HINCKLEY RAIL FREIGHT TERMINAL

Summary: Transport and Access

CPRE Leicestershire

Oct 2023

Note: To be read in conjunction with the Access and Rights of Way Plans (document reference: APP-017 to APP-020) and the Public Right of Way Appraisal and Strategy (document reference: 6.2.11.2)

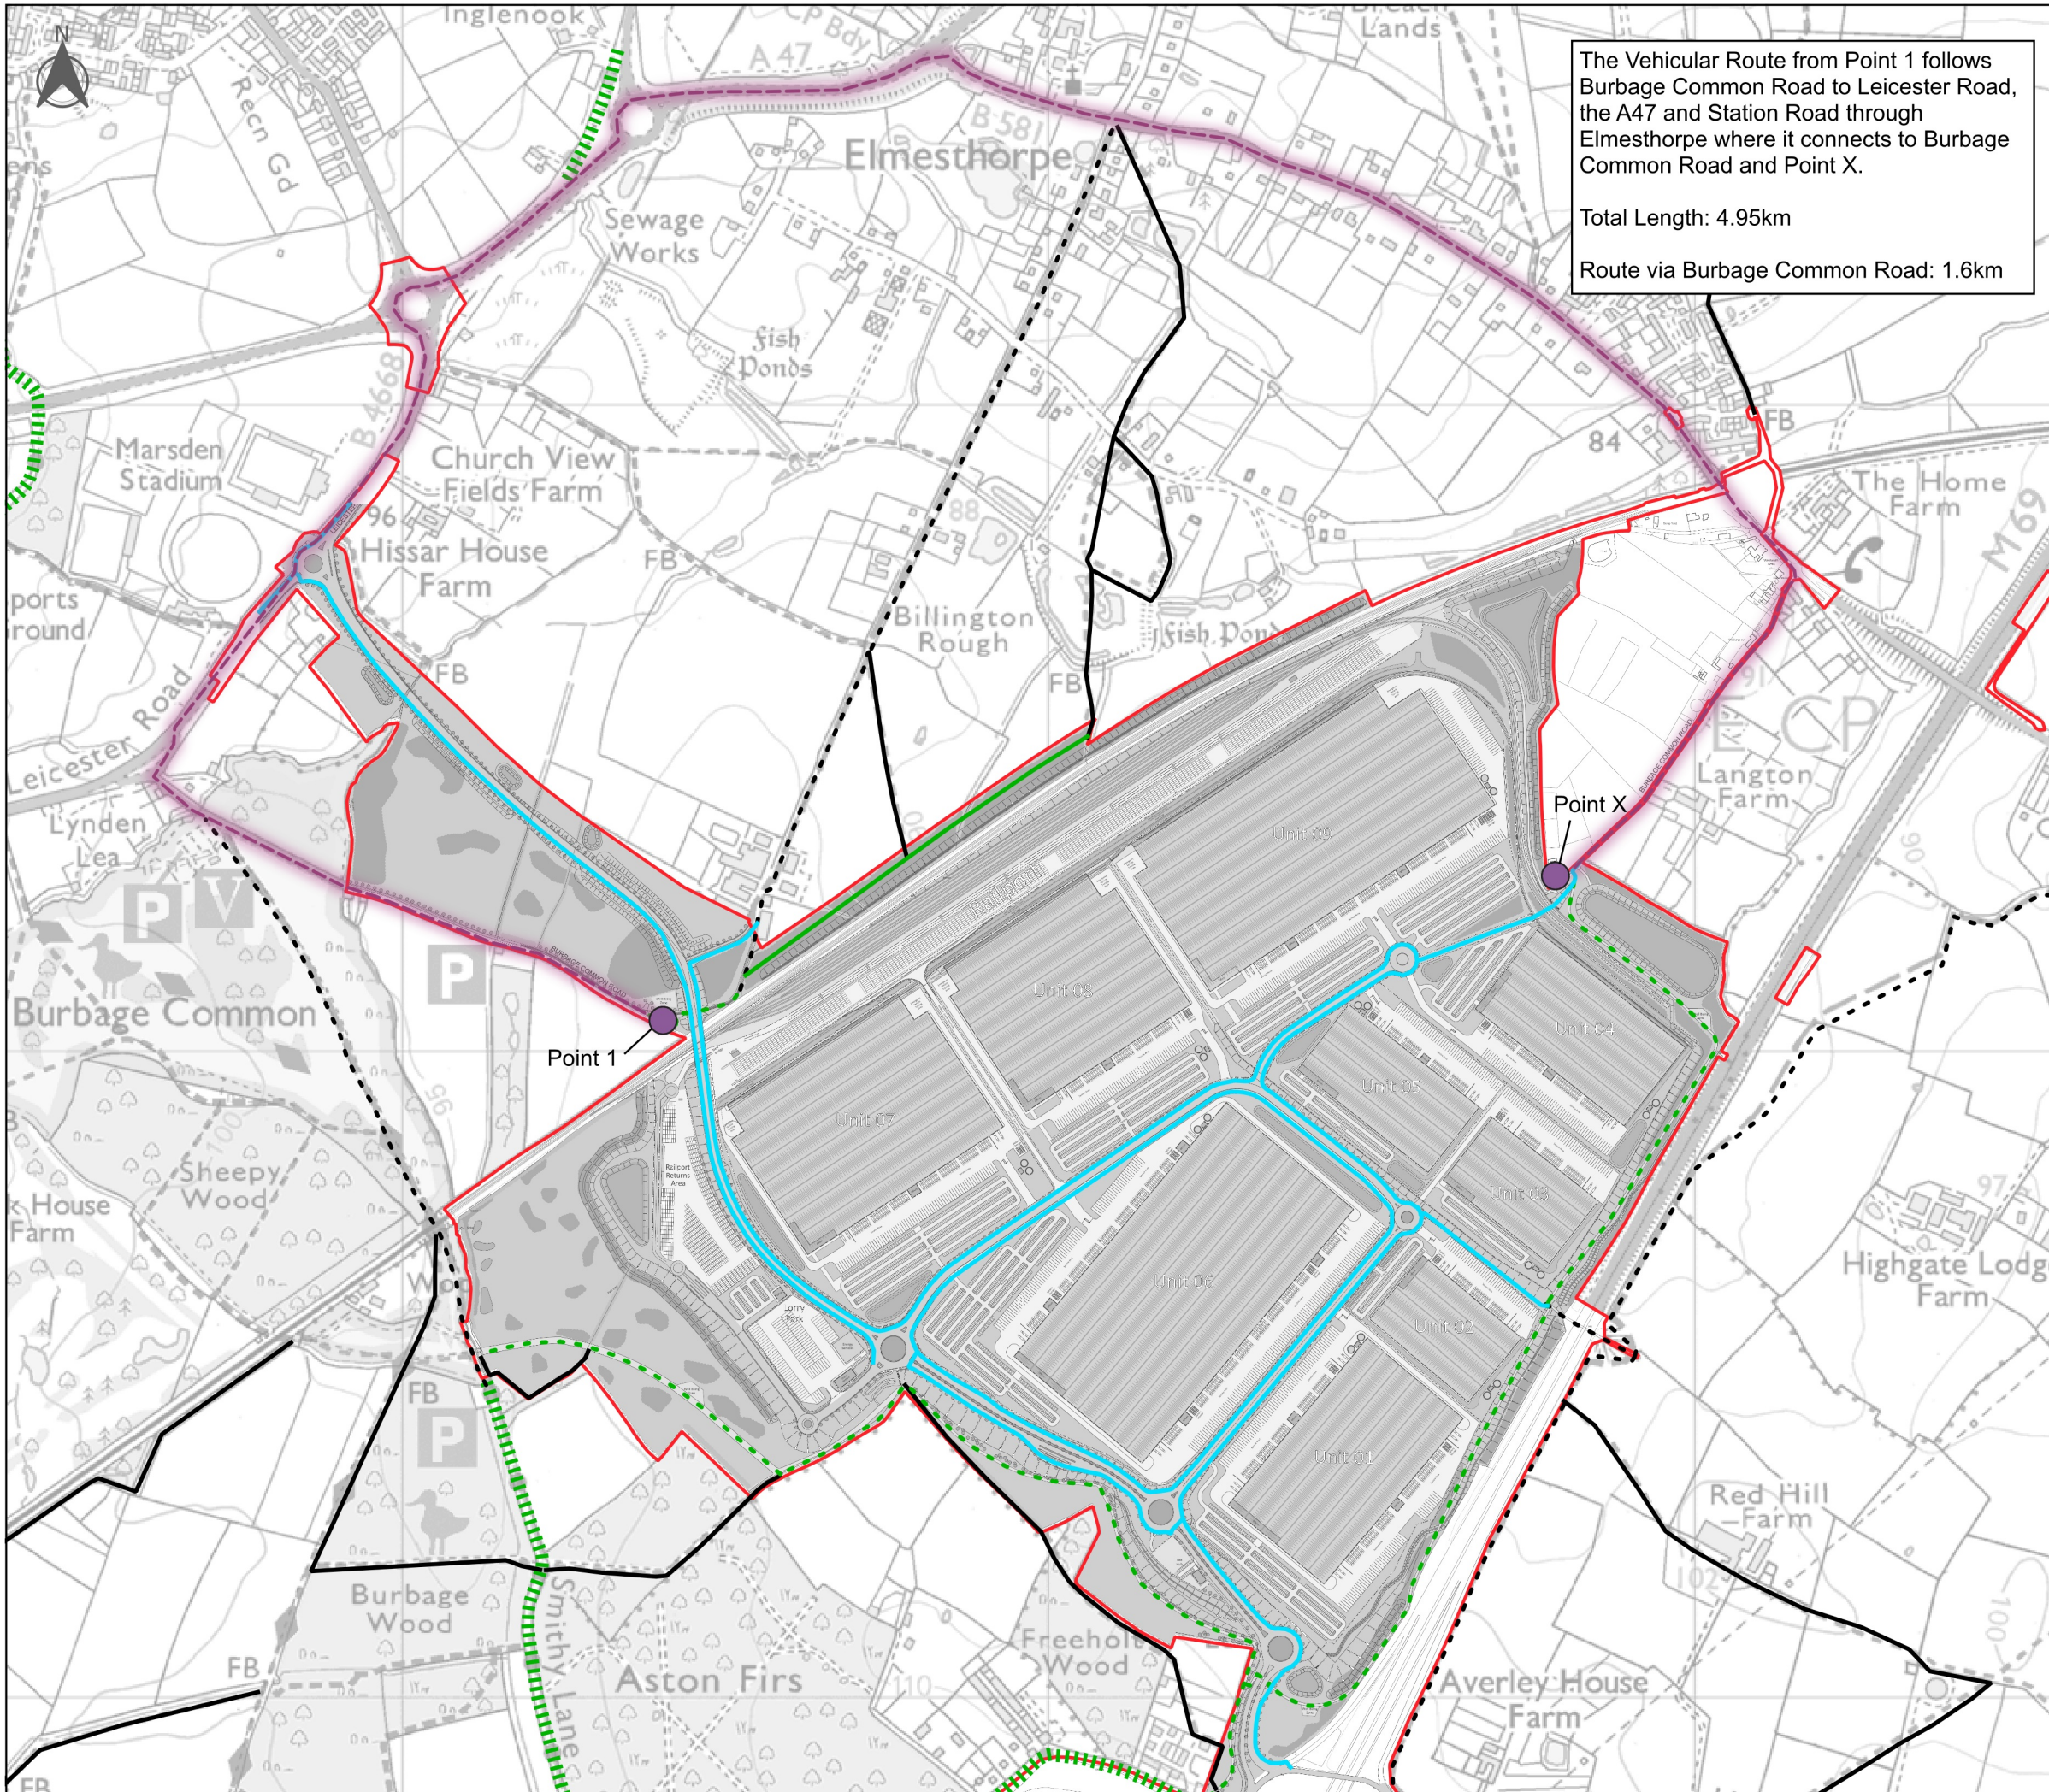
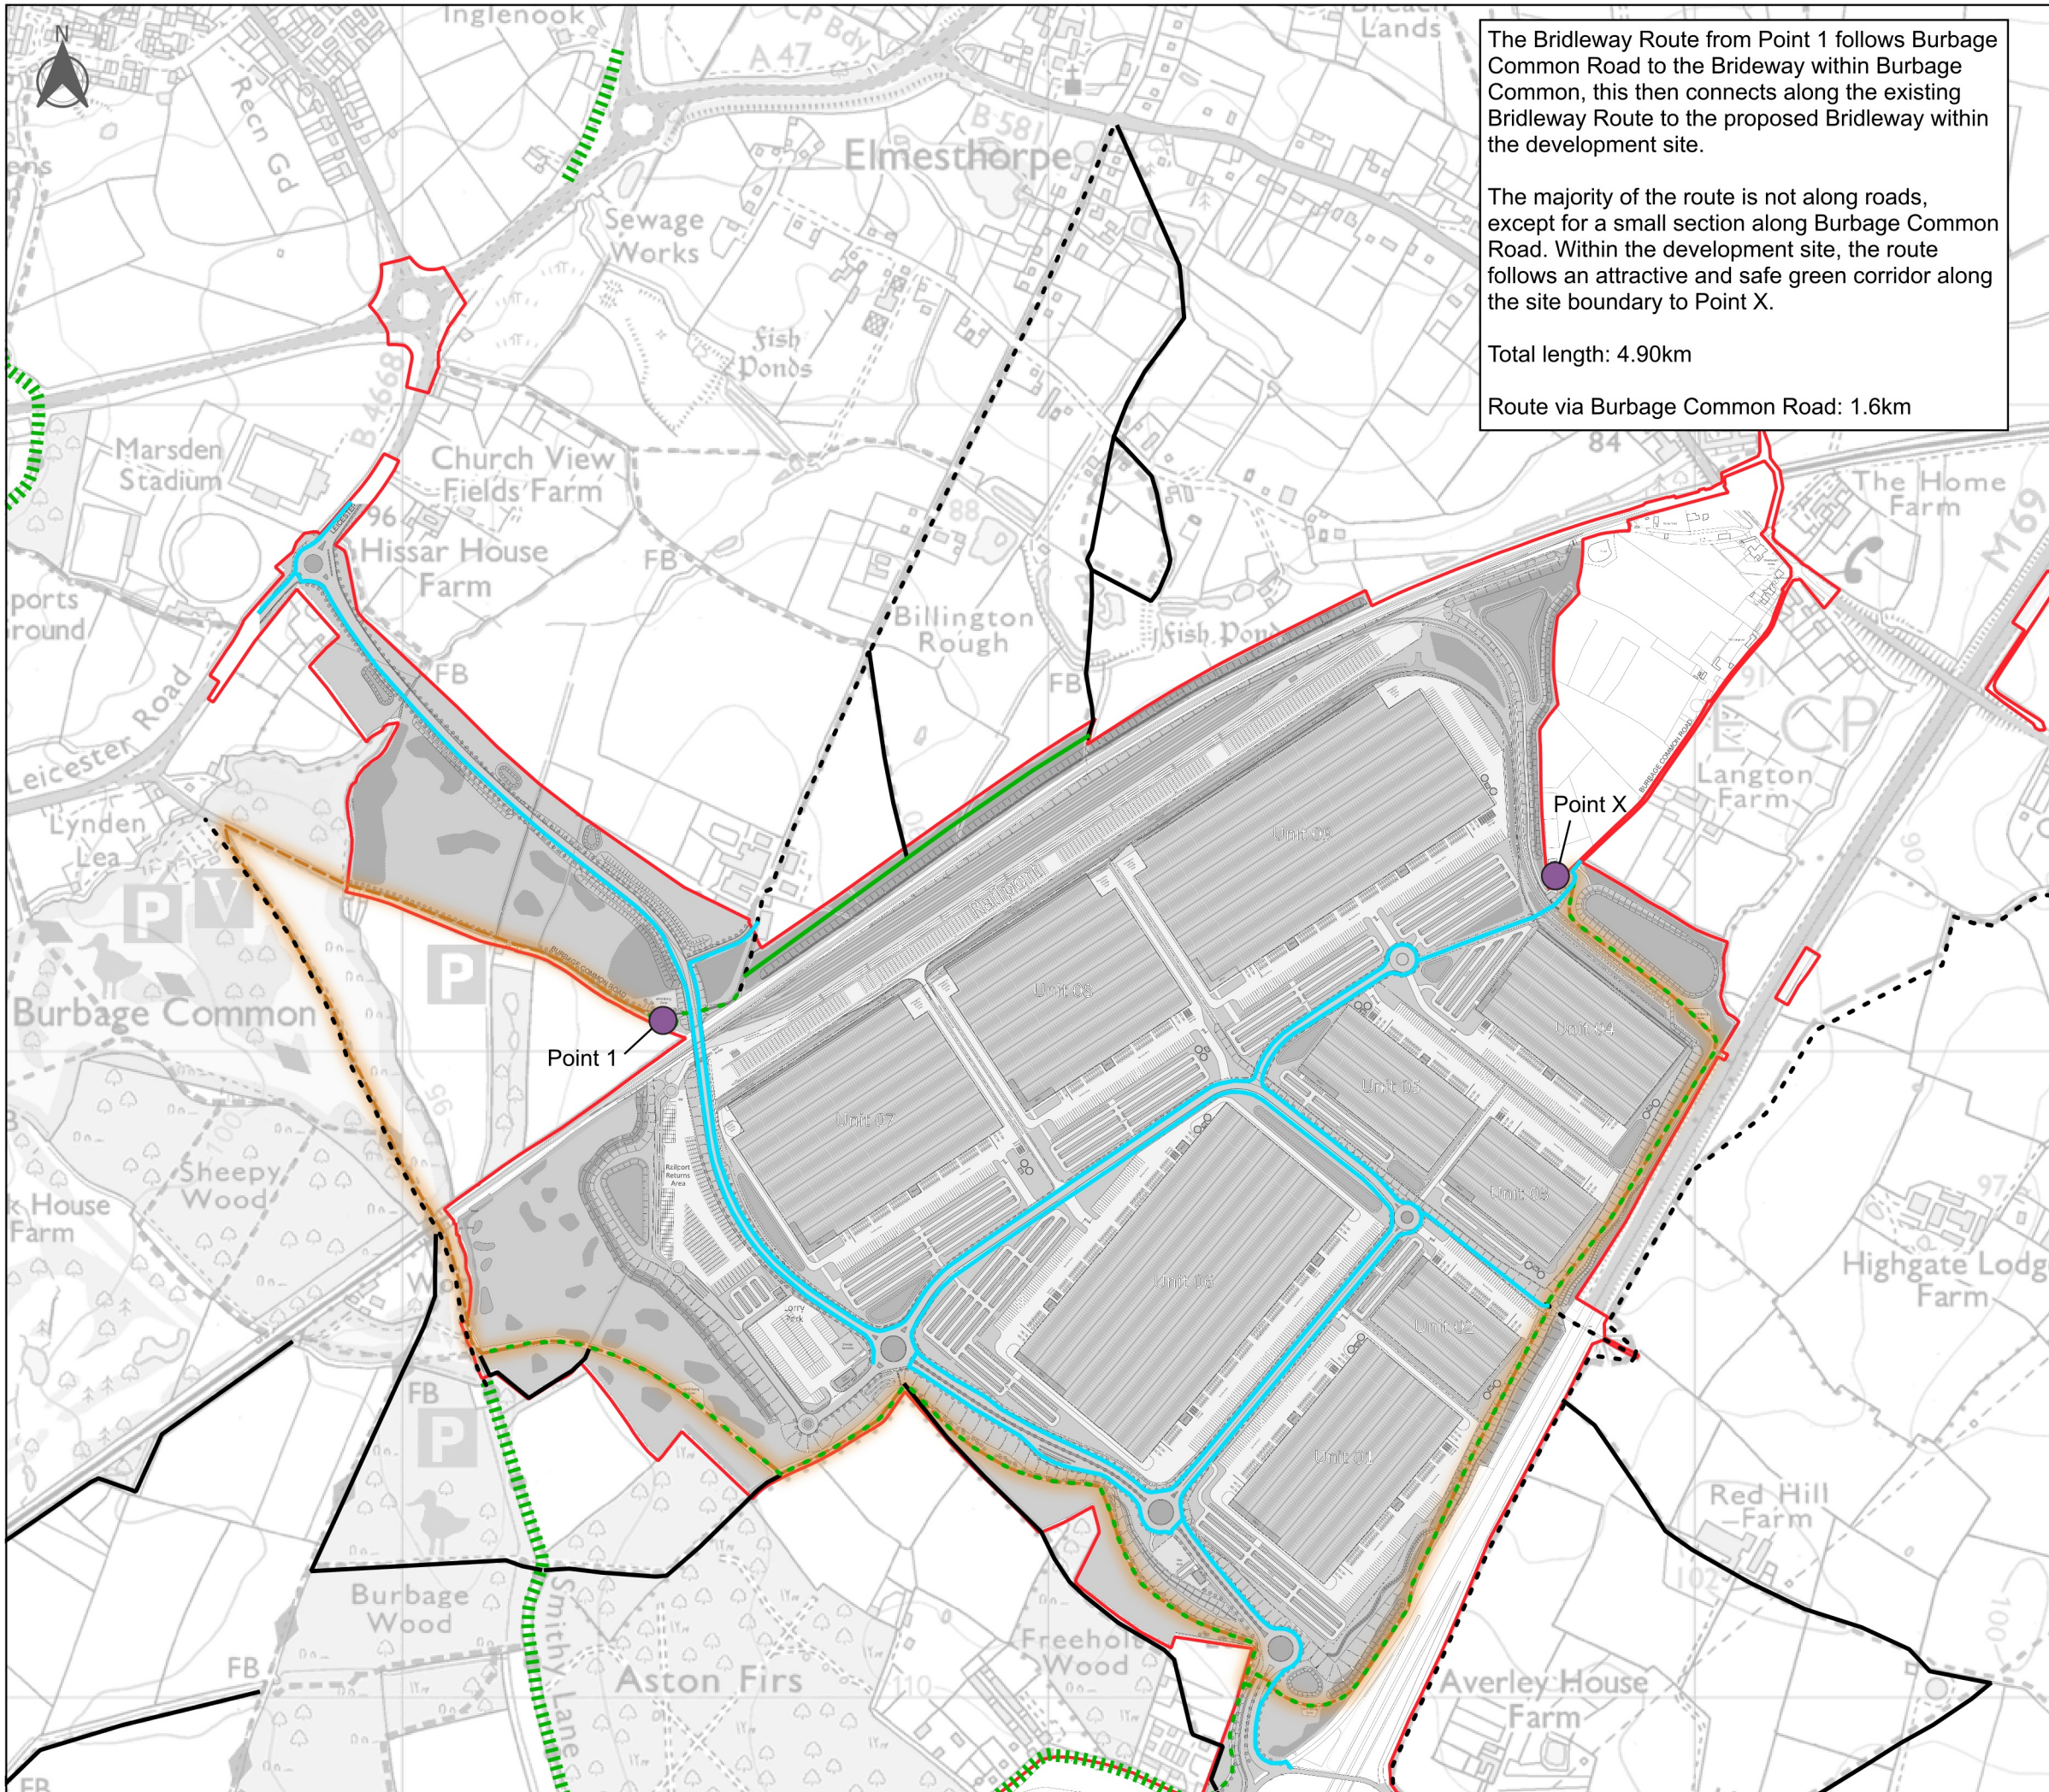
8.2.3 The Assessment paints a glossy picture of potential improvements to the PROW network which is curtailed drastically between Hinckley and the motorway, as well as losing the opportunity to walk on the quiet Burbage Road. Pedestrians are forced onto the newly-constructed link road, then through the Industrial Park, or on a circuitous bridleway around the proposals. None would enjoy the attractiveness of the current routes through open countryside.

8.2.4 Equally, residents of Stoney Stanton, Sapcote and Sharnford would find the PROW links to Burbage Common restricted in quantity and quality.
